**WEST SUSSEX COUNTY COUNCIL
STRATEGIC PLANNING CONSULTATION**

SUBJECT: BR/132/14/DOC-Application for approval of details reserved by conditions 3 & 4 of previously approved planning application BR/256/10 - relating to materials of external walls and roofs & visibility splays.

Melrose, 7A, Nelson Road, Bognor Regis, West Sussex, PO21 2RY

102 - splay

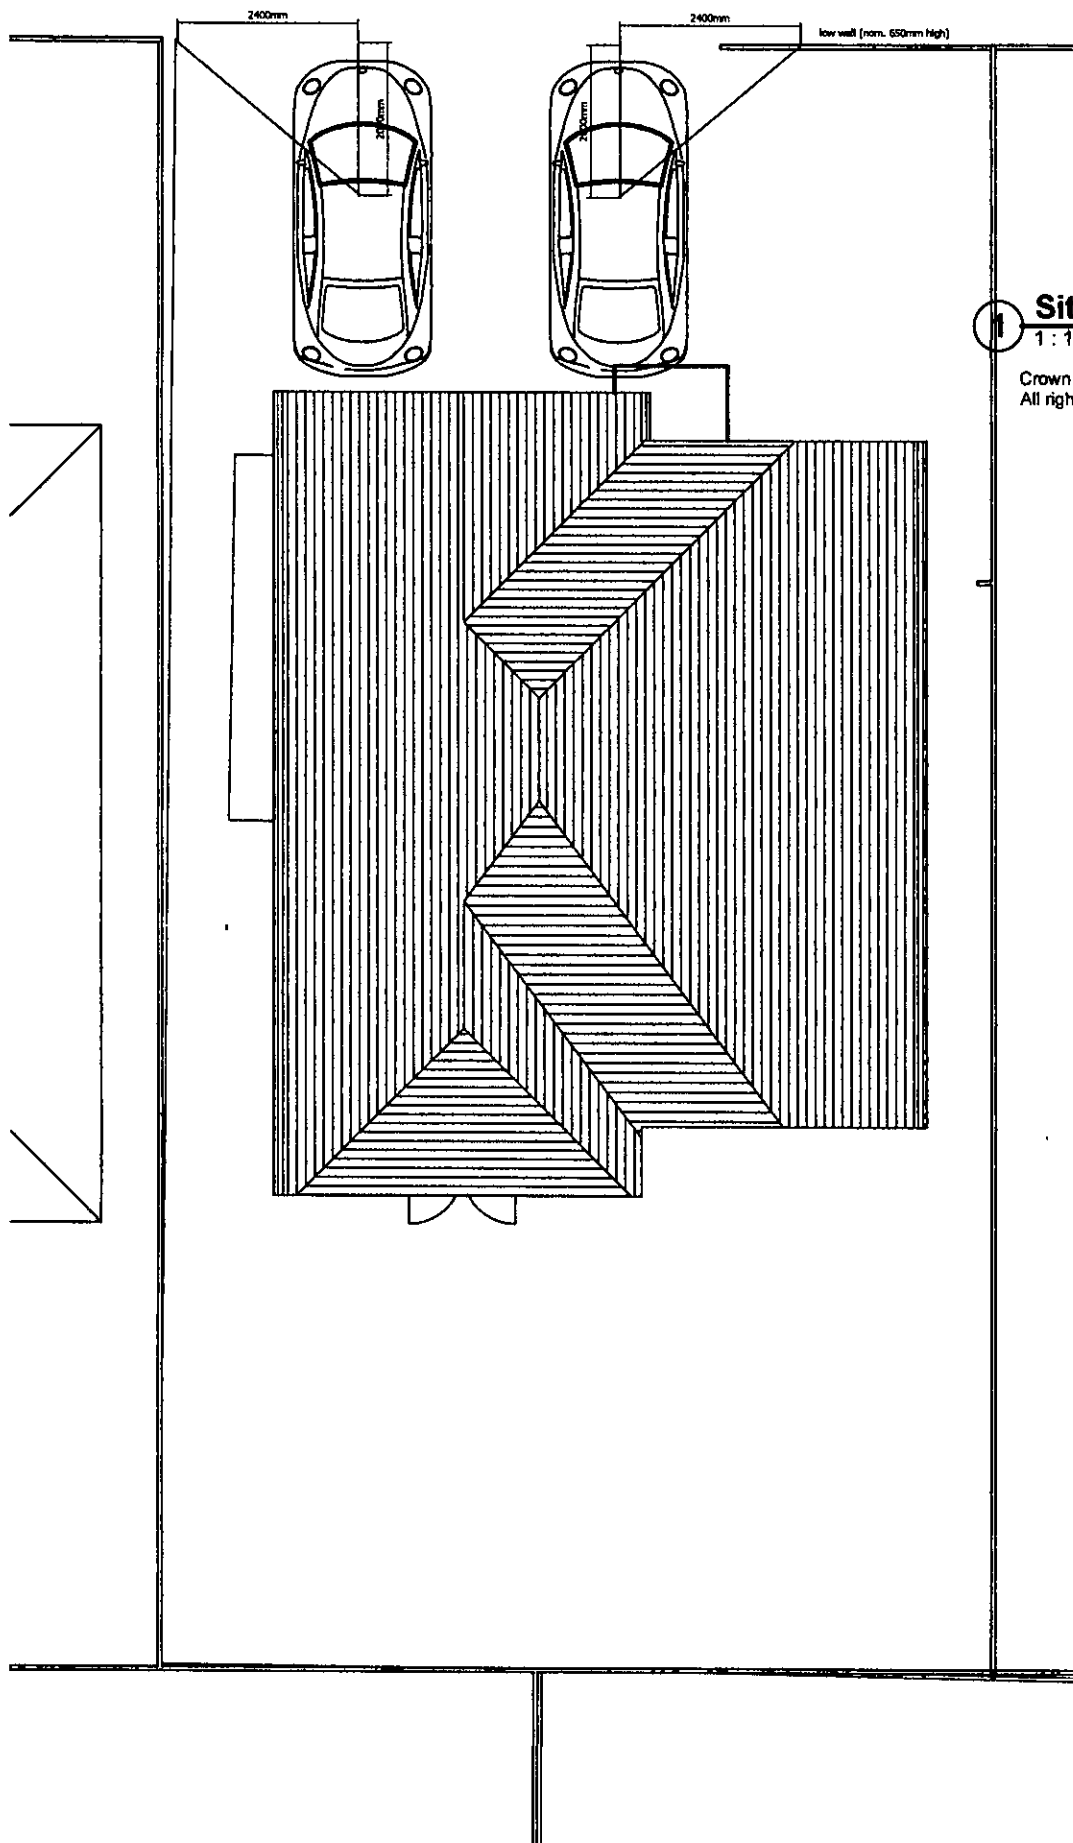
The proposed pedestrian visibility splays for pedestrians are acceptable therefore this condition can be released.
